One of these was about why some of the car parking spaces in St. Martins Approach (SMA) car park were designated as not meeting standards. I was unable to find the answer in any of the documentation, particularly in the Highways Technical Notes document. You explained that the minimum requirement for a viable car parking space is 2.4m by 4.8m.

This email focusses on the car park spaces. I have conducted some research and will split this into the SMA car park and the Winston Churchill Hall (WCH) car park.

3.2 CAR PARKING

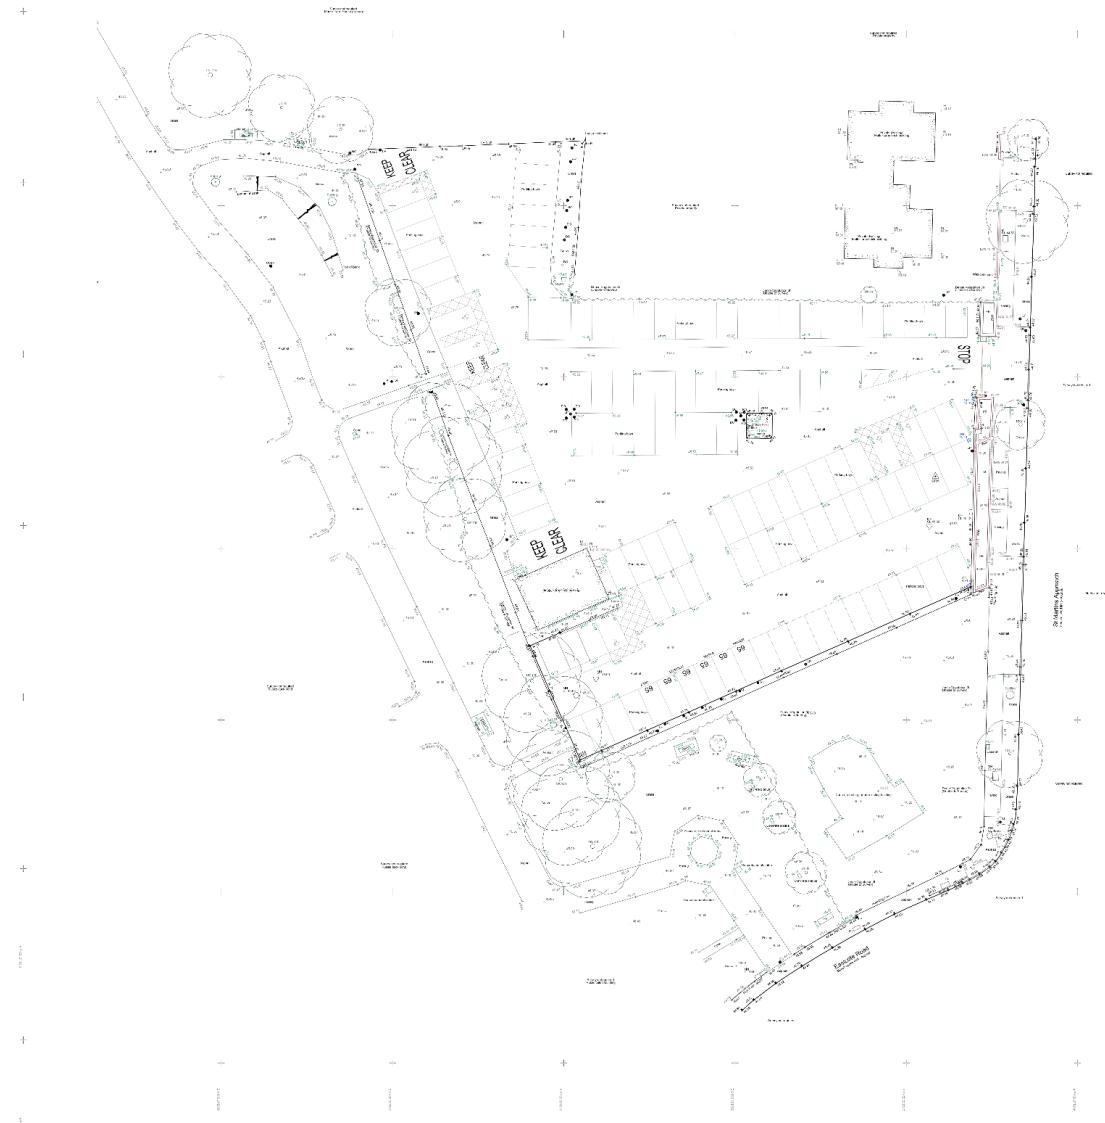
On Friday, 27th February, I went to SMA car park to measure some of the spaces on the right-hand side of the car park running alongside number 1, St. Martins Approach. There were 19 which were deemed sub-standard. I met Councillor Peter Smallwood there and we agreed that the ones I had measured were indeed sub-standard. However, if the white lines were re-drawn and the bushes were trimmed back the 19 spaces could usefully make 16 (my estimate) instead. The Highways Technical Notes document says that 36 are substandard, but with the simple re-drawing of the spaces the car park could probably hold 113 viable spaces instead, with a loss of just six.

Winston Churchill Hall Ruislip

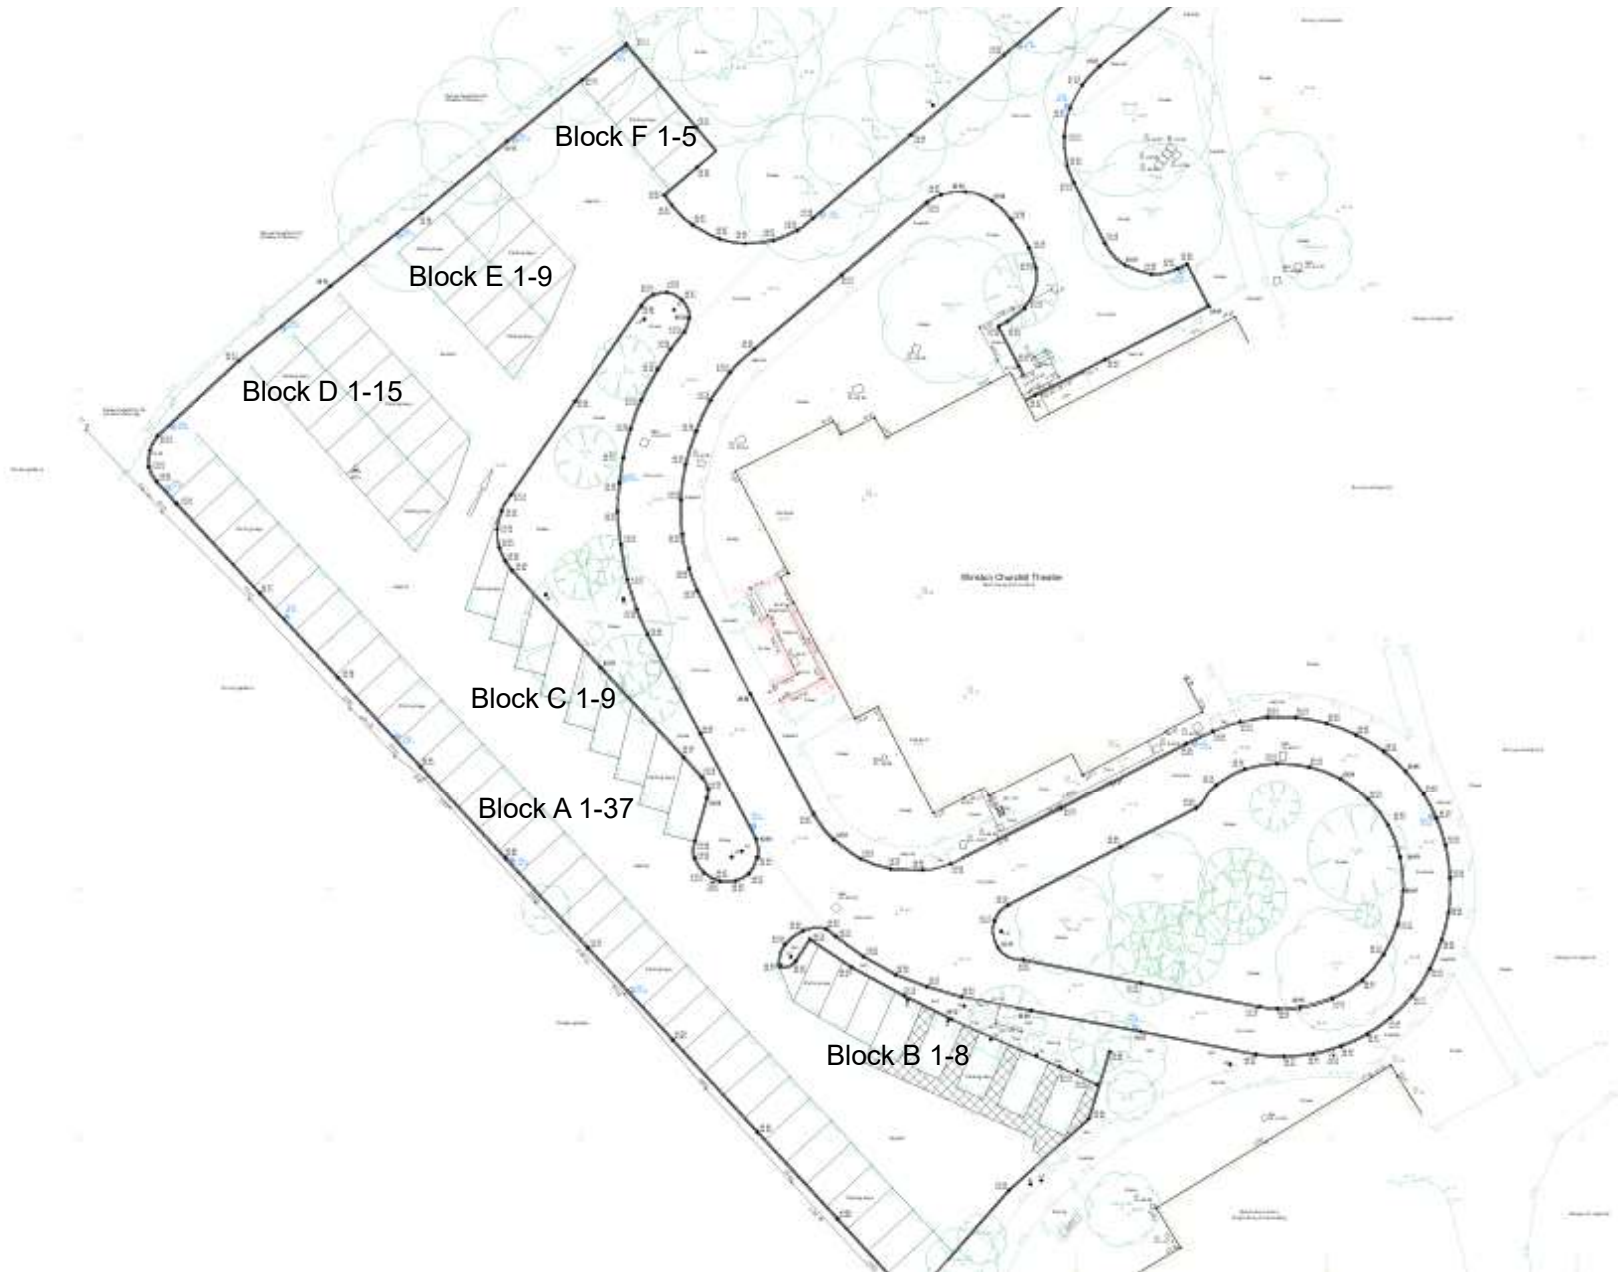
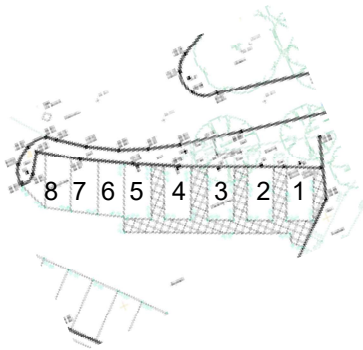
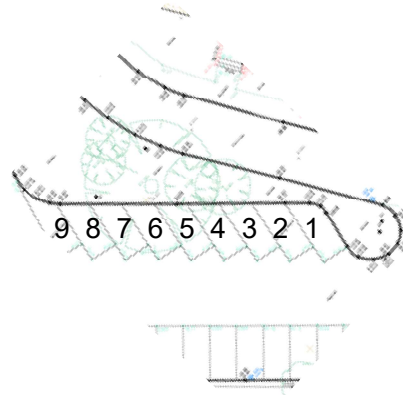
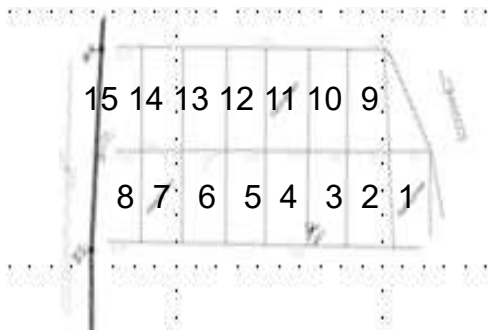
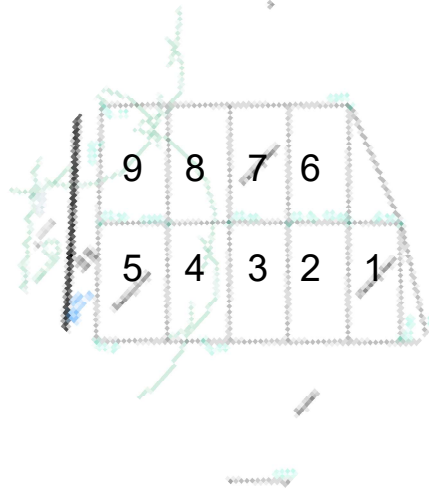
Yesterday, 28th February, my friend [REDACTED] and I spent some time measuring the car parking spaces in the WCH car park. We measured the 83 spaces each within the white lines and found that no space reached the standard length of 4.8m. Only seven spaces measured the width as 2.4m or more. Using the same logic as used for the SMA car park, it would appear that all are substandard and therefore not applicable. However, this is nonsense as those spaces could be redrawn to conform to the standard thereby reducing the number of spaces available from 83 to roughly 77. I have included two documents in this email which give the WCH car park layout split into blocks, which aided our measuring activity, plus a spreadsheet giving the measurements for each space.
